KITTTITAS COUNTY COMMUNITY DEVELOPMENT SERVICES

October 23, 2018

Subject: Williams Shoreline Substantial Development Permit (SD-18-00001)

DRIVEWAY PROFILE & SECTIONS
 DRAWING 11

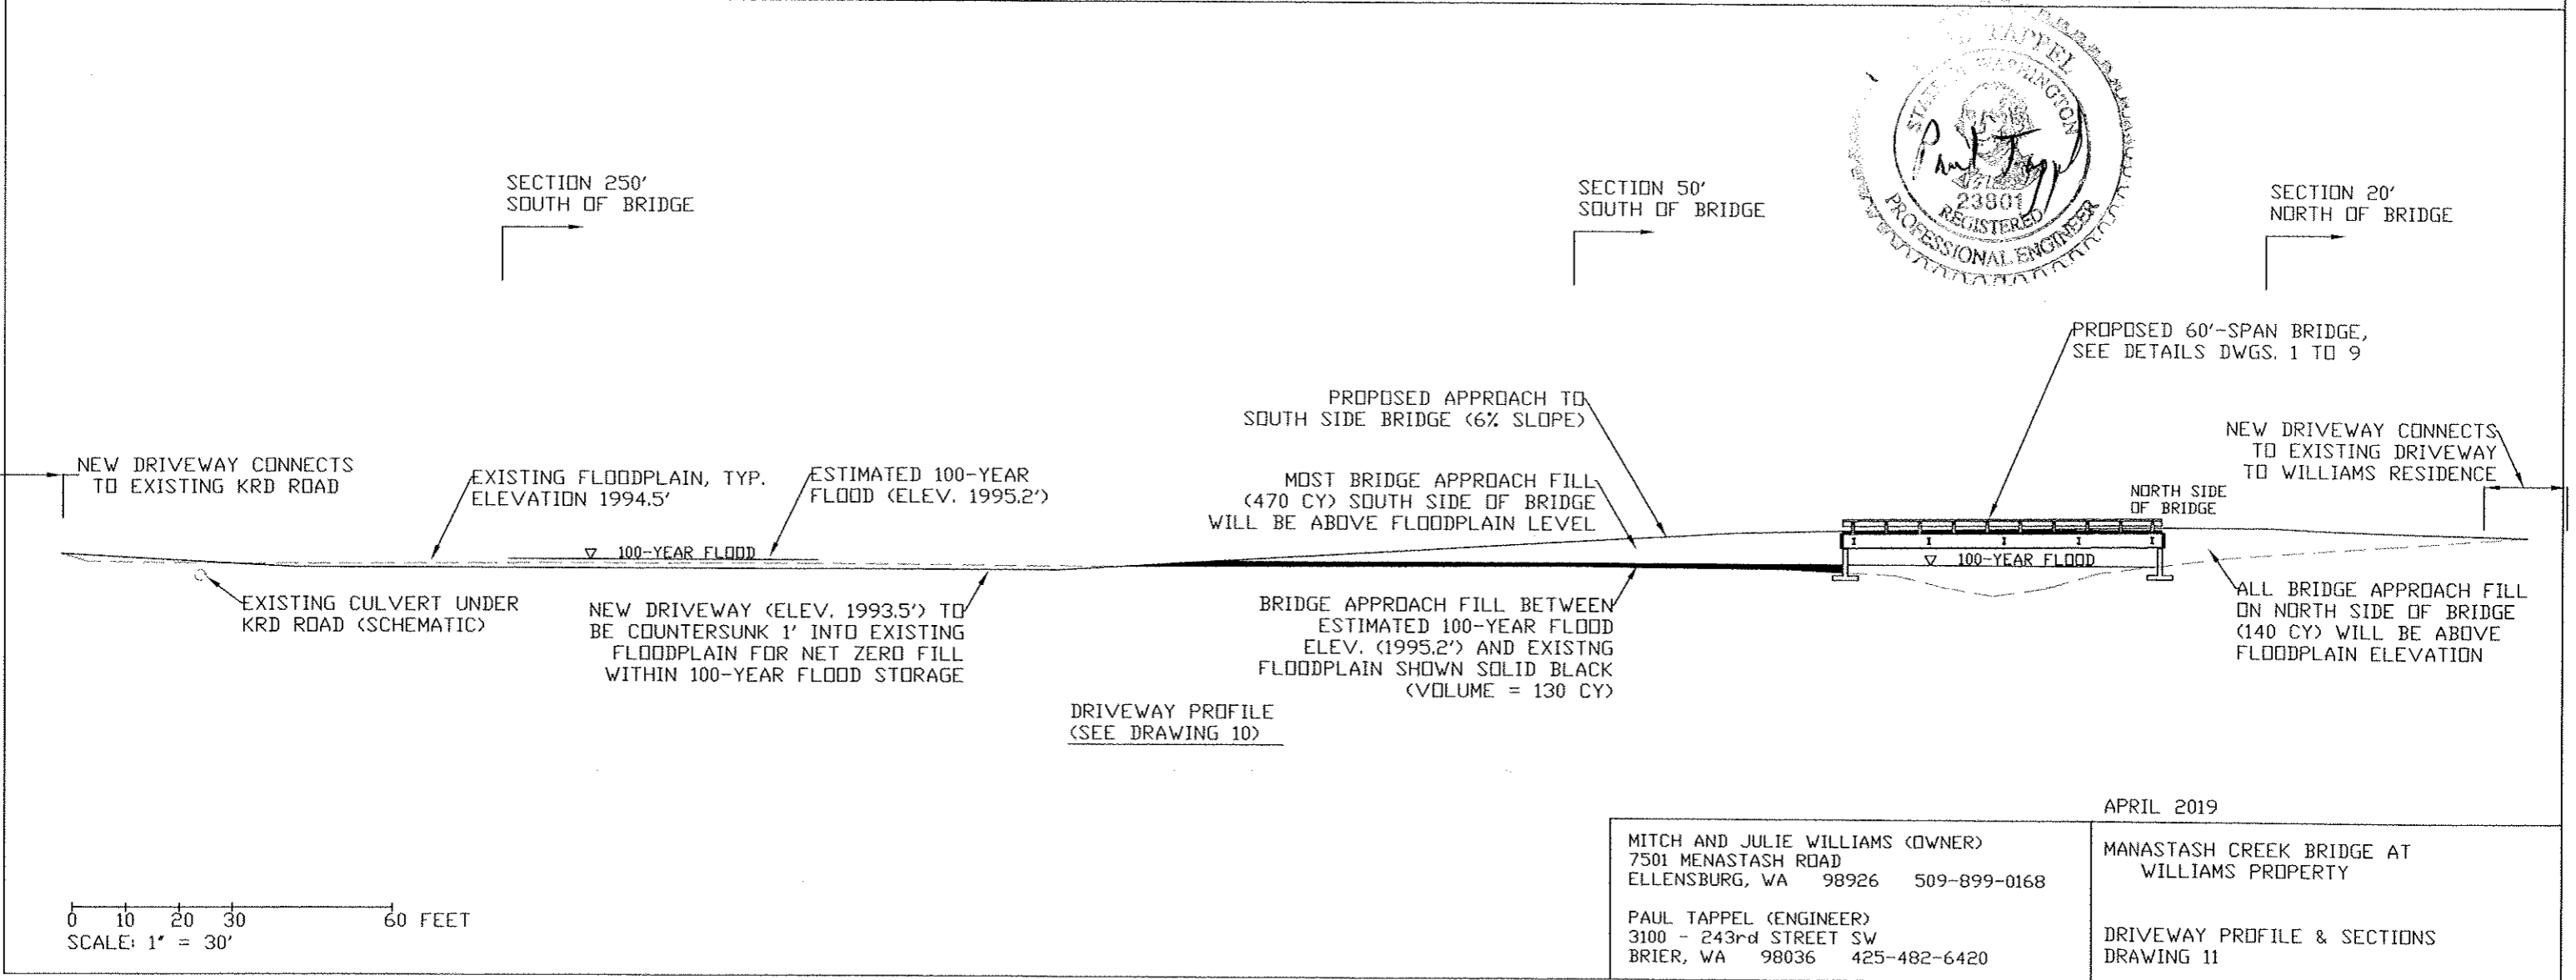
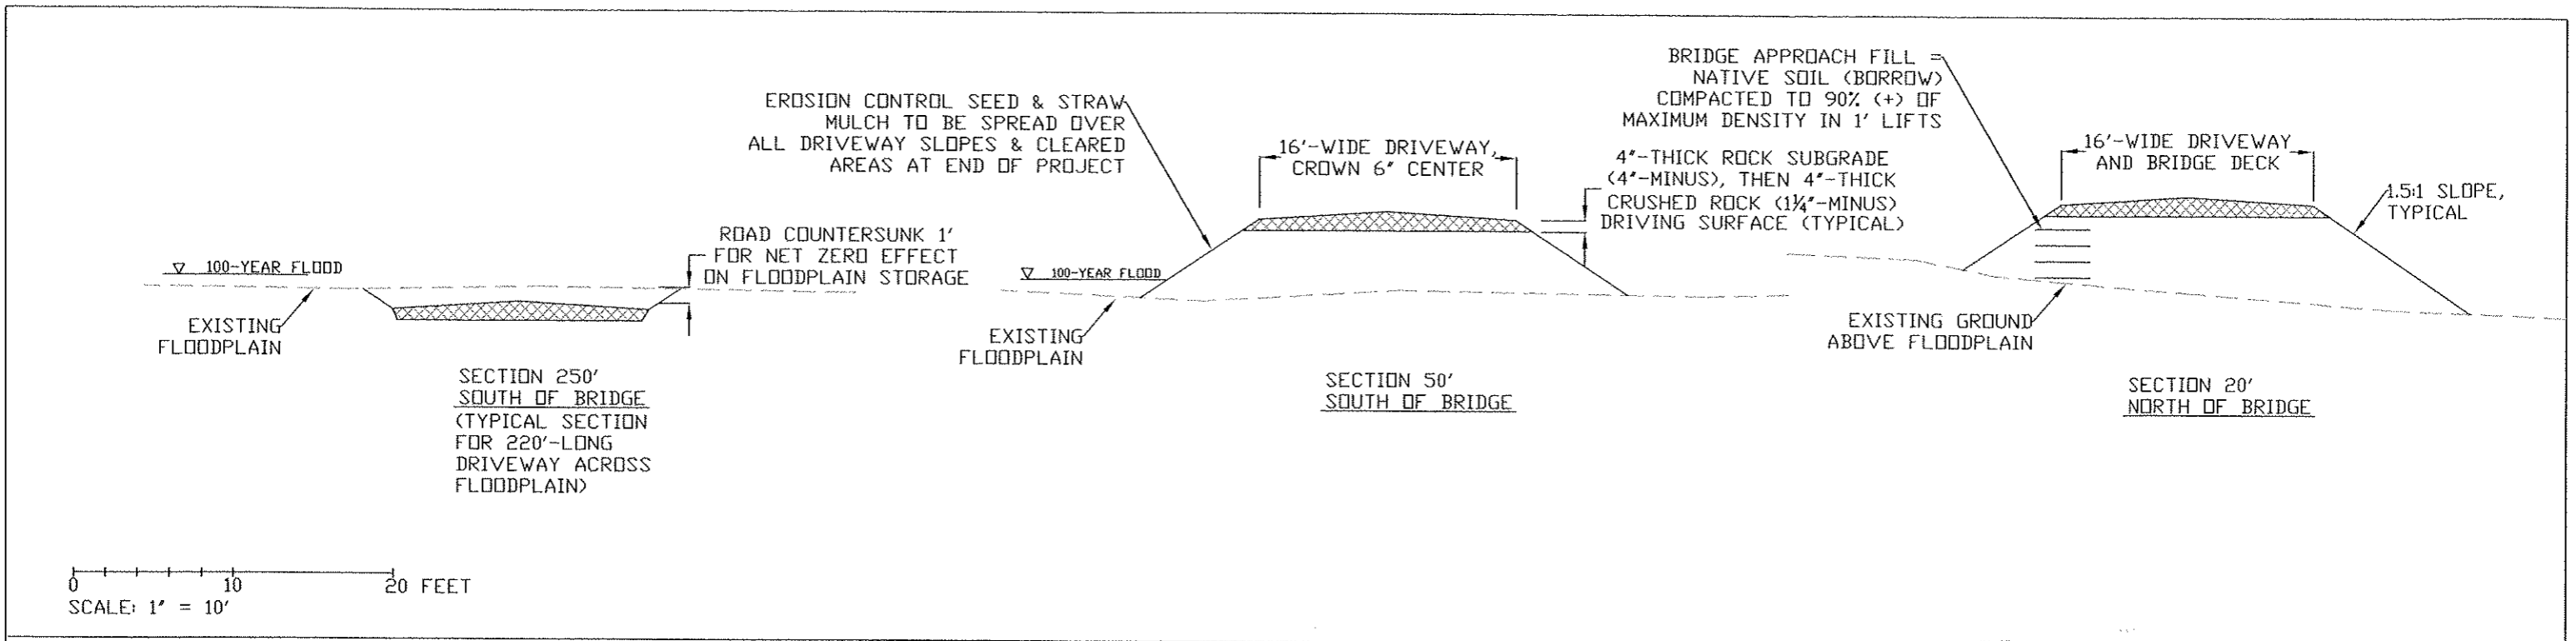
1. Detailed specifications on the new portion of driveway to be constructed. This information must include type and quantity of fill, grading information, composition of proposed driveway, and disturbed area measurements.
